**PUBLIC HEARING--DEVELOPMENT REVIEW BOARD
CITY OF ALBUQUERQUE**

Project# 1005450

This letter is to serve as a comment to the Development Review Board (“Board”) regarding the proposal for Project #1005450, known as Longacre Subdivision (“Longacre”). This comment reflects the shared position of individuals (“Ditch Users”) who own residential properties in the on Spur Court NW, an east-west public street which lies south of the proposed development, or on Gabaldon NW, a north-south public street which lies west of the proposed development.

Ref: DRB project #1005450
#08DRB-70504, Preliminary Plat for Longacre Subdivision

PRELIMINARY PLAT FOR
LONGACRE SUBDIVISION
 BEING A REPLAT OF TRACTS 331-B, 336, 337 MIDDLE RIO GRANDE CONSERVANCY DISTRICT MAP NO. 35 WITHIN THE TOWN OF ALBUQUERQUE PROJECTED SECTION 12, T. 10 N, R. 2 E, NMPM,

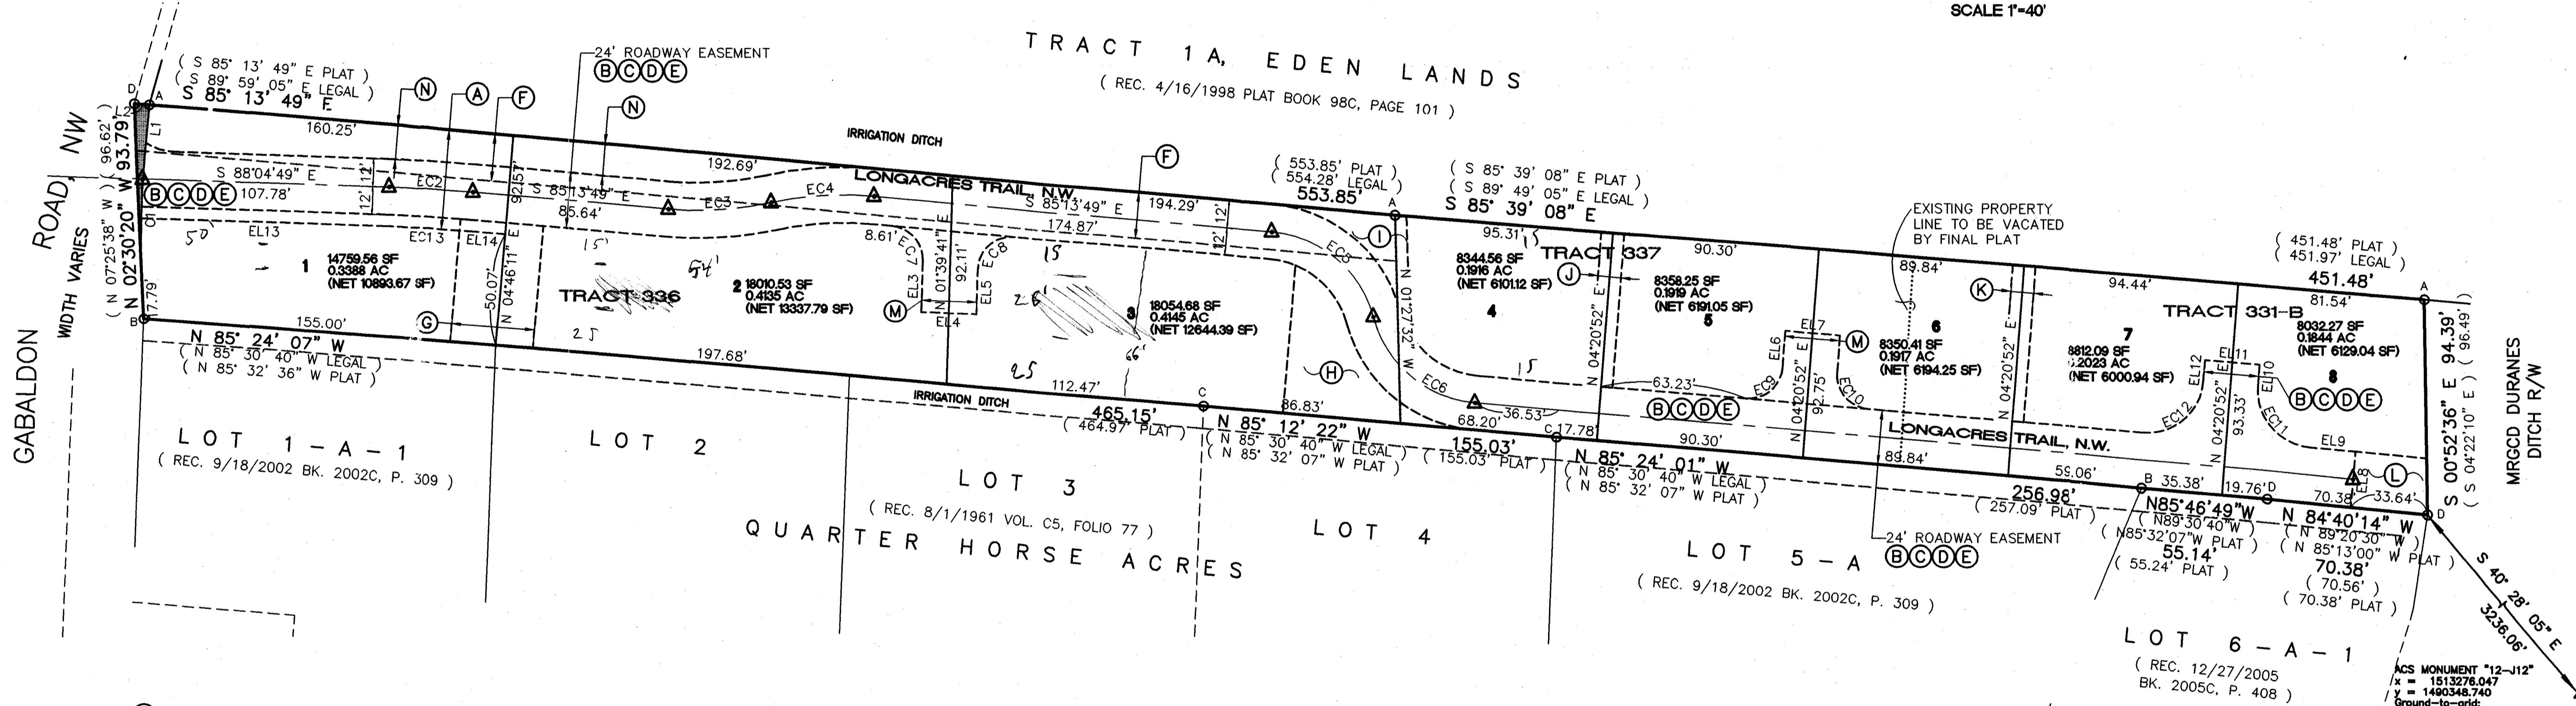
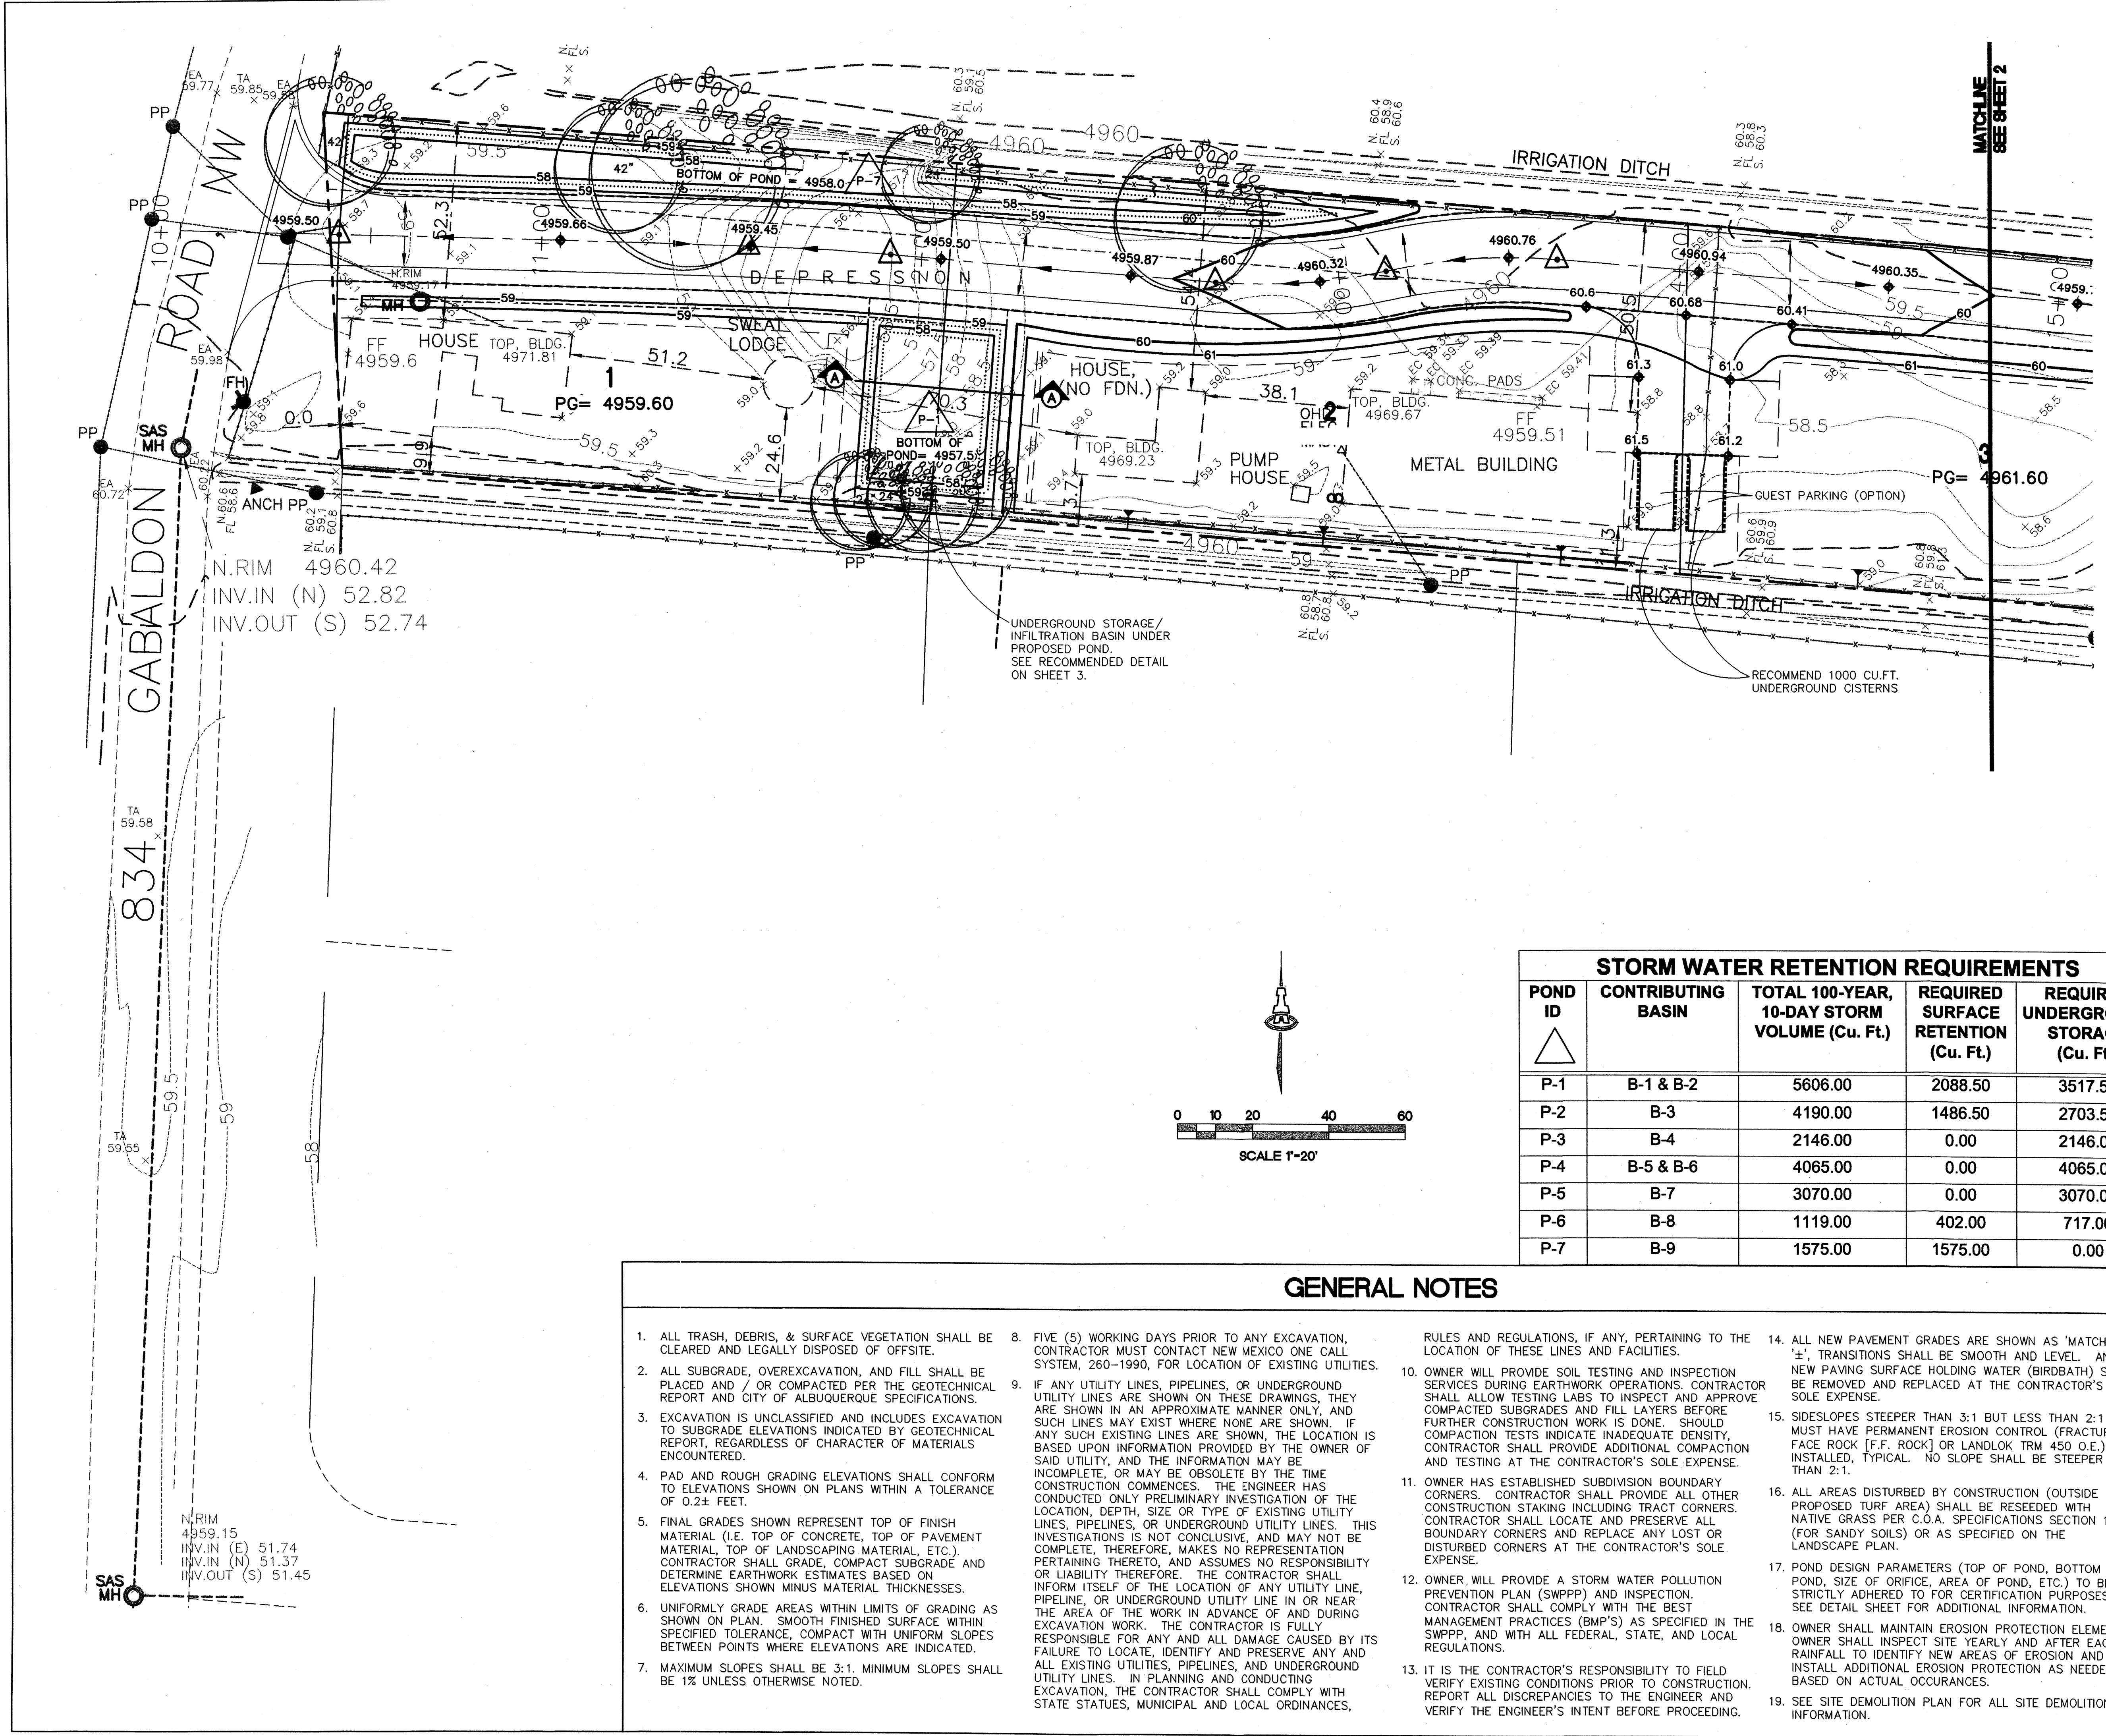
I am writing in protest of the survey description of the boundary between Quarter Horse Acres Subdivision (QHA) and the proposed Longacre Subdivision. The survey for the Longacre property is using "found" rebar of unknown history that do not match the boundary line described in older plats. The Longacre survey has also redefined critical boundary points at the northeast portion of QHA with no apparent basis for doing so and placing them in substantial disagreement with existing plats. A large dimensional error also appears in the statement tying the Longacre survey to a City geodetic monument.

In researching boundaries shown in the Longacre preliminary plat, it was evident that legal descriptions for the lands were inconsistent and flawed. Records filed by various owners over the last 30 years give a variety of legal descriptions. All descriptions use the NW corner of QHA as a reference point, but all seem badly flawed in that they result in considerable northward divergence of the tract boundaries from the northern boundary of QHA. Legal descriptions of Tract 336 often do not match descriptions of Tracts 337 and 331-B at their common boundary. Mapping services at the City, the County, and the

Locking down the location of the legal northern boundary of QHA has significance for lot owners within QHA, but is also important because the original boundary is used as a reference for legal descriptions of several surrounding tracts of land. Of concern is the fact that the original plat of QHA was tied to a Section corner marker lying within Tract 337 and has never been directly tied to the AGRS. Critical markers for the exterior corners of QHA have either all been destroyed or possibly disturbed, including the points identified on the plat as the SW and SE corners of the Longacre Subdivision.
